SSD 9813 – Mixed use development at Donnison Street, Gosford

Thank you for your correspondence via Major Project portal (ref: PAE-654) on 8 October 2019, requesting Transport for NSW (TfNSW) to review and comment on the above.

The proposal seeks concept approval for a six-stage development comprising clearing of the site, construction of five mixed use towers and approval for the physical Stage 1 works including demolition, site improvements and vegetation removal. The documentation in support of the proposal has been reviewed and comments provided in **Attachment A**.

Figure 3.6: Surrounding public transport network

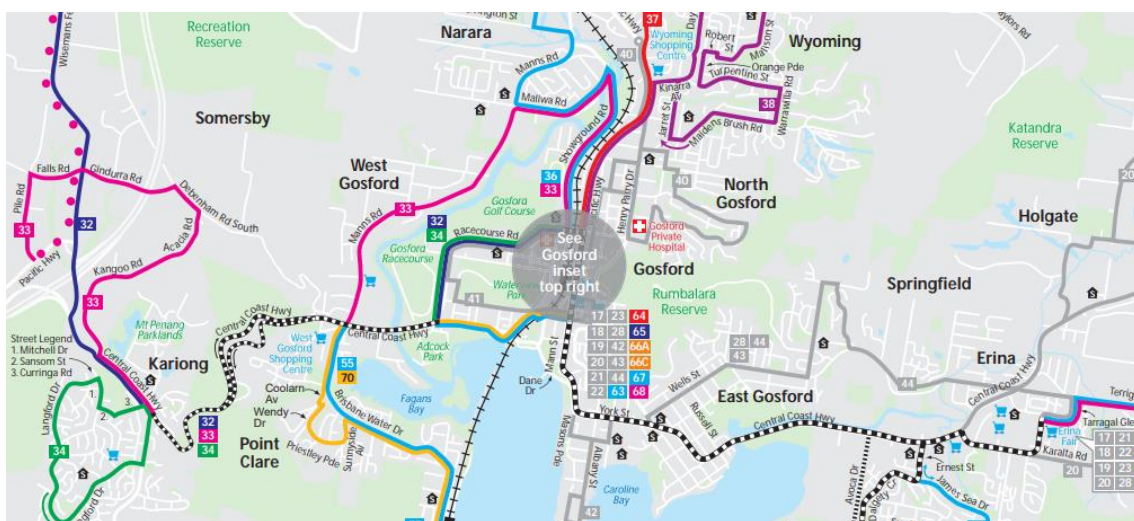
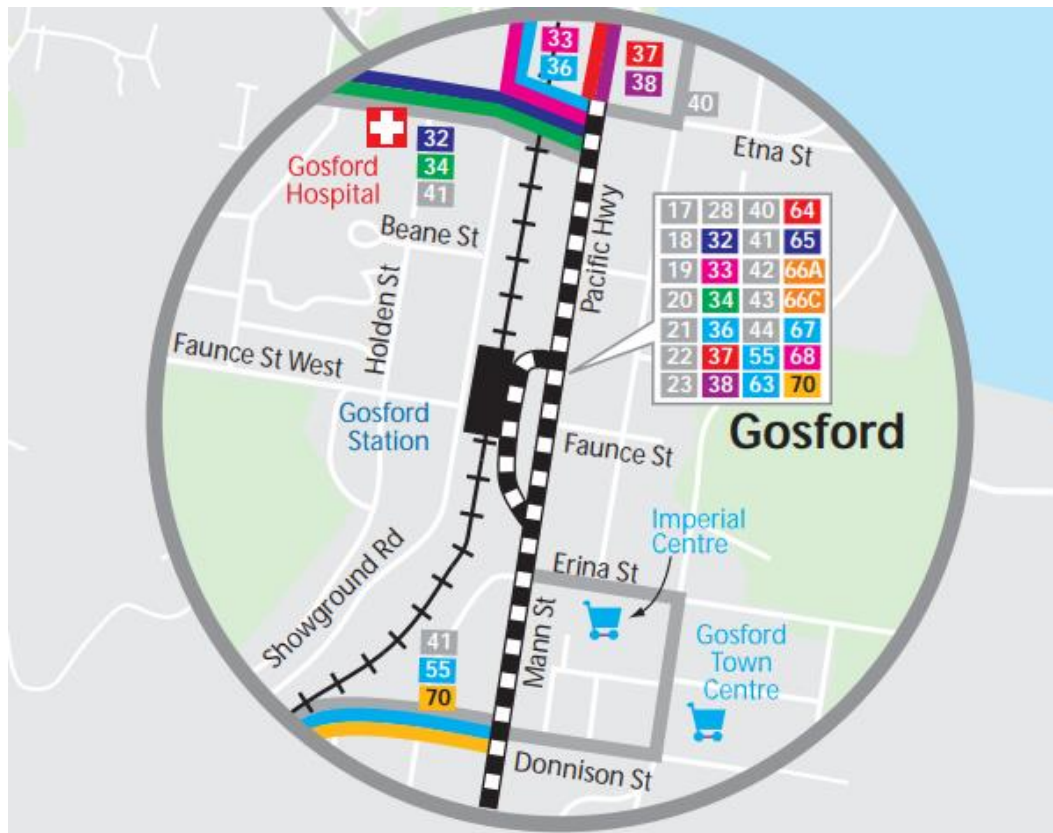
- Table 3.2 provides the Public Transport summary in the vicinity of Gosford Station. Bus route number 41 which operates on Donnison Street at the front of the site is not included in the table.
- Section 6.4 states that “*the site is well served by several high frequency rail services and bus routes*”. It is advised that the bus stop on Donnison Street at the front of the site is currently served by one low frequency route.

The information in the TIA report including any ramifications to the proposal should be revised accordingly.
